01 March 2021

The Examining Authority Case Team
Aquind Interconnector Project
National Infrastructure Planning
Temple Quay House
2 The Square
Bristol
BS1 6PN

**DCO Application for the Aquind Interconnector Project
SDNPA Deadline 8 Submission**

Figure 15.49: Indicative Landscape Mitigation Plan Option B(1) (south)

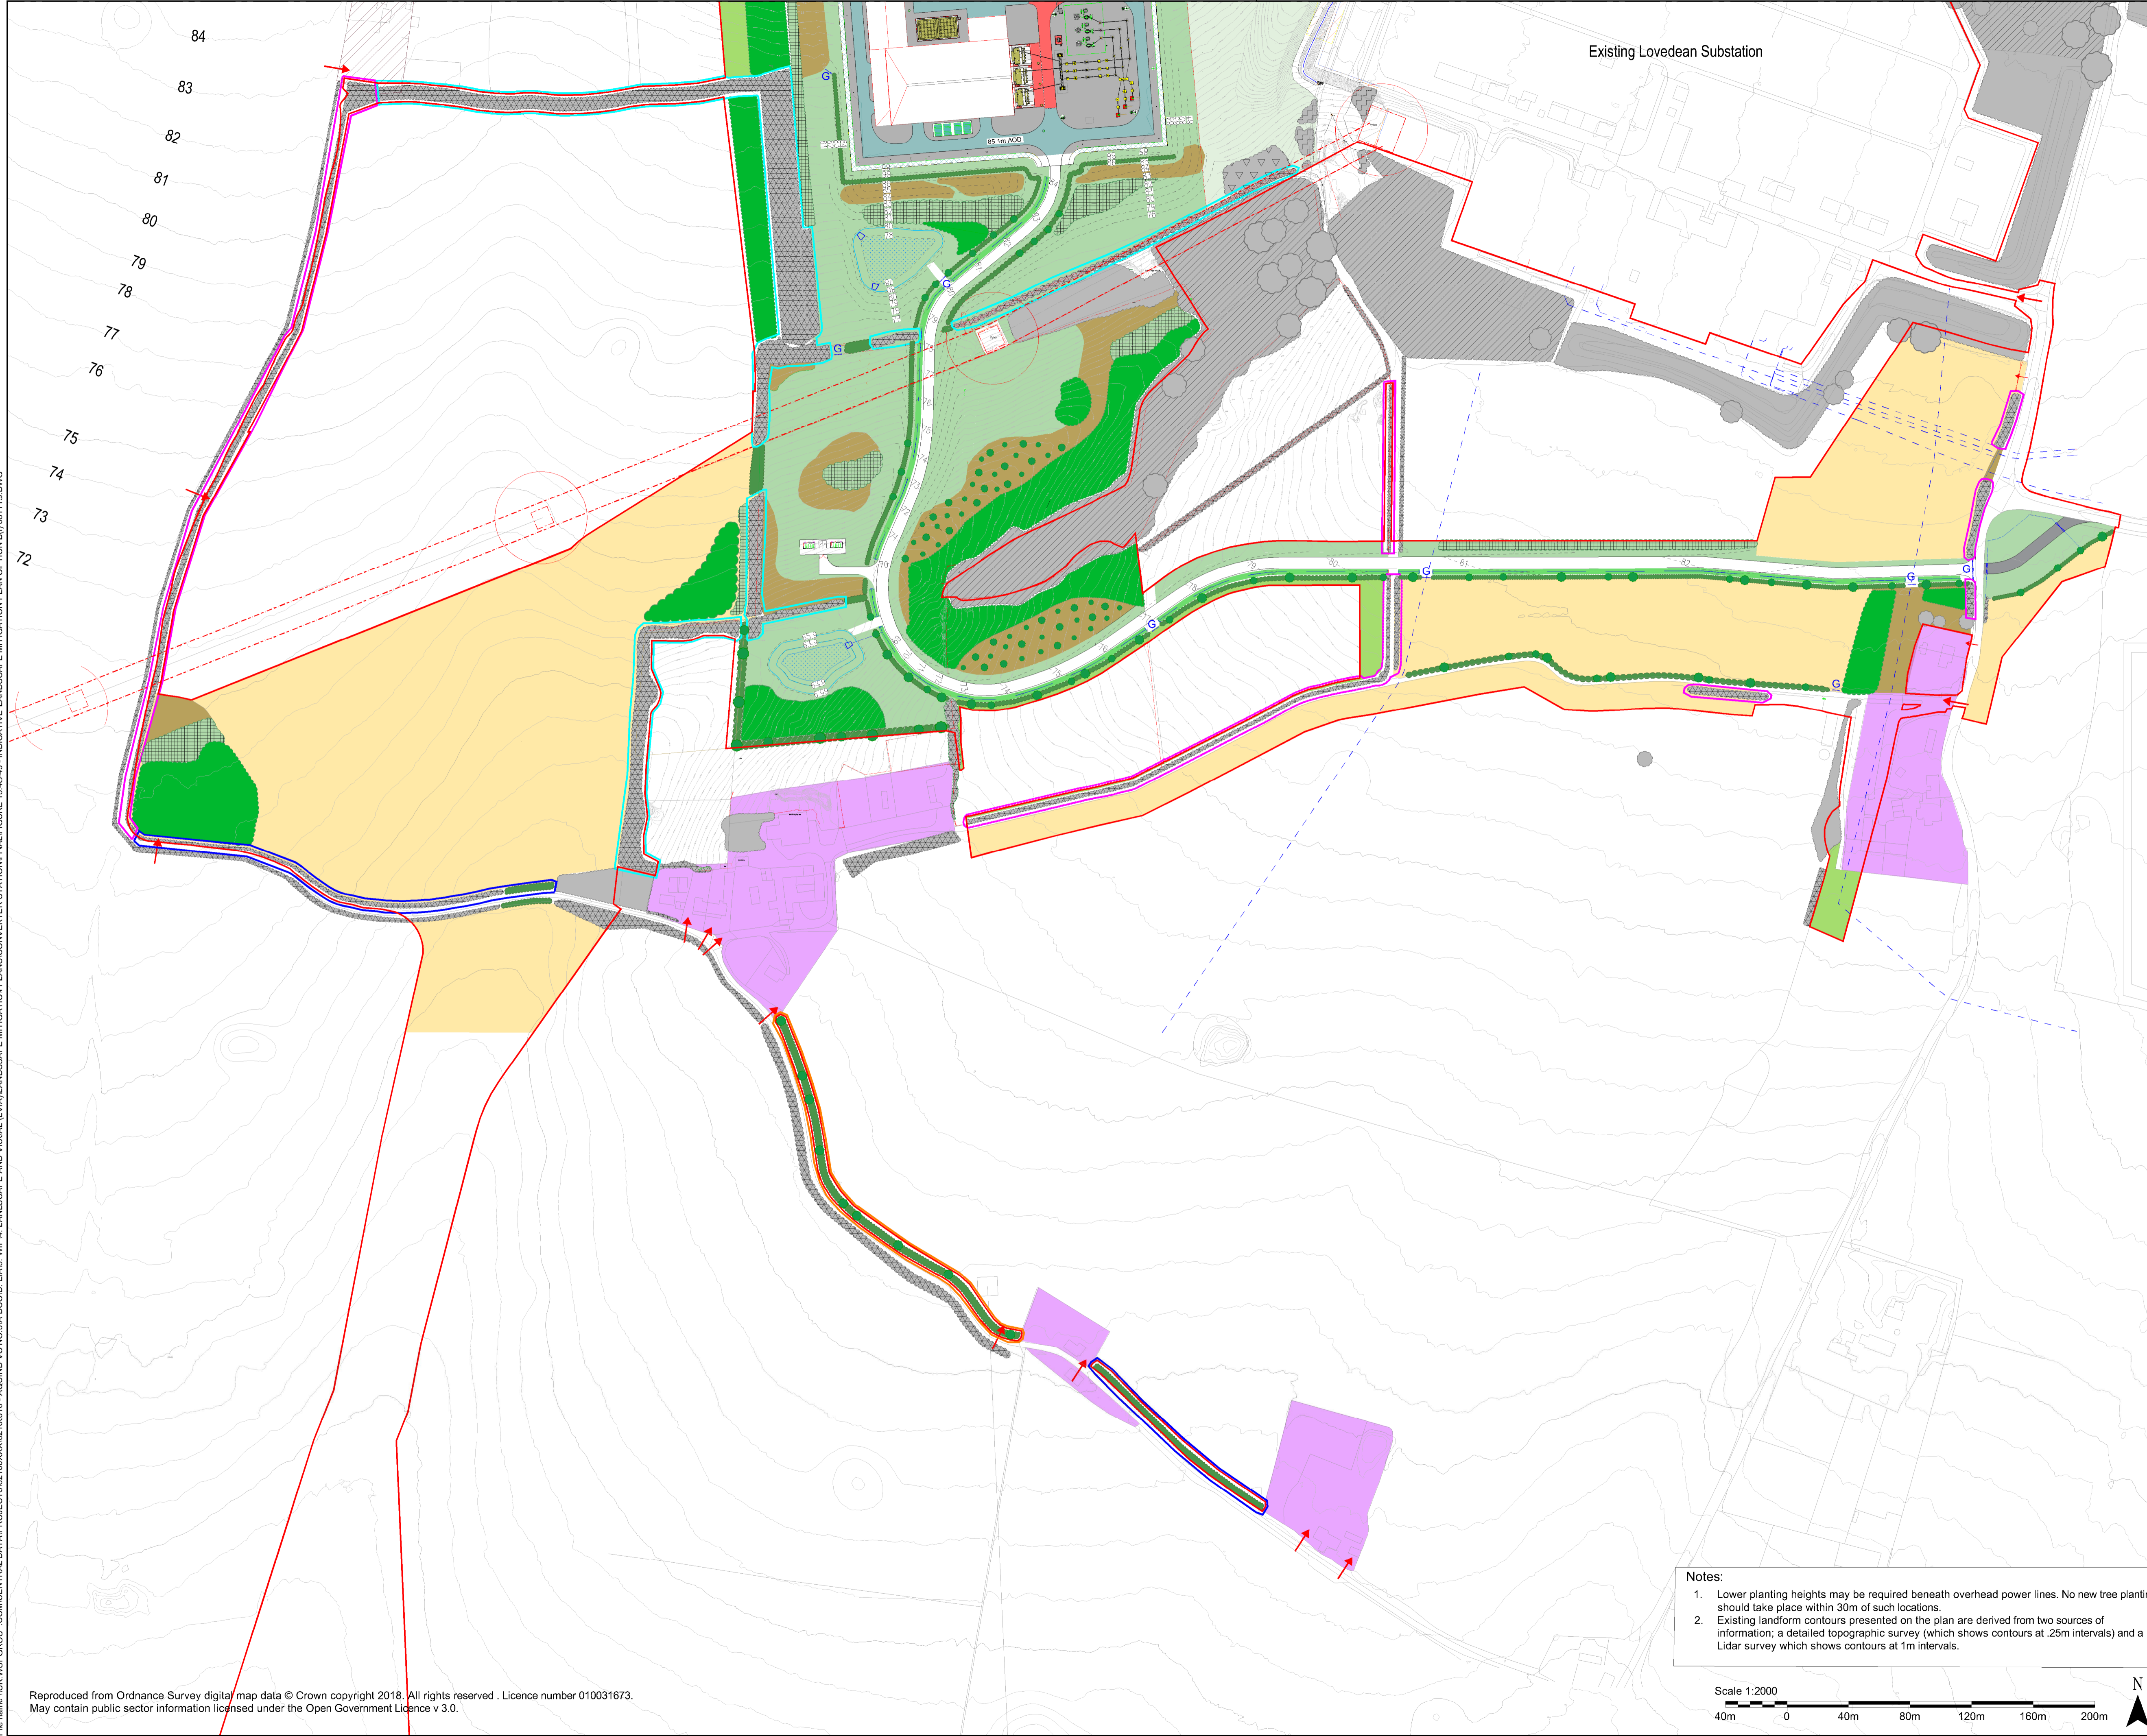
- a. In relation to agenda item 4.1 the SDNPA noted that there are still two options for the converter station location identified in the landscape mitigation plans and confirmed that Option B(ii) remains our preferred option.

In relation to the landscape mitigation proposals the SDNPA confirmed at the hearing that two of our concerns with the applicant's landscape mitigation proposals raised at Deadline 6 remained. These were firstly the inadequate additional woodland and hedgerow planting set out in the proposals and secondly the strategy to deal with Ash die back.

In respect of the first the SDNPA noted the operational constraints relating to planting in close proximity to the Converter Station, but remained concerned at the lack of more substantial woodland planting in areas further away from the Converter Station, which would also assist in combatting the likely degradation of the landscape through the creation of smaller field areas not viable for agricultural purposes.

In respect of the second, the application had set out the ash dieback strategy in reports, however this is not fully reflected on the landscape mitigation plans, in respect of the existing woodland areas, hedgerows and individual trees inside the Order Limits.

Post hearing note: A S106 planning obligation, including provision for new woodland planting, is proposed (see below) to mitigate some of the landscape harm arising from the proposal. In relation to the ash dieback comment the applicant has agreed to reflect this in the key of the landscape mitigation plans to be submitted at Deadline 8 and the SDNPA is content on this matter.
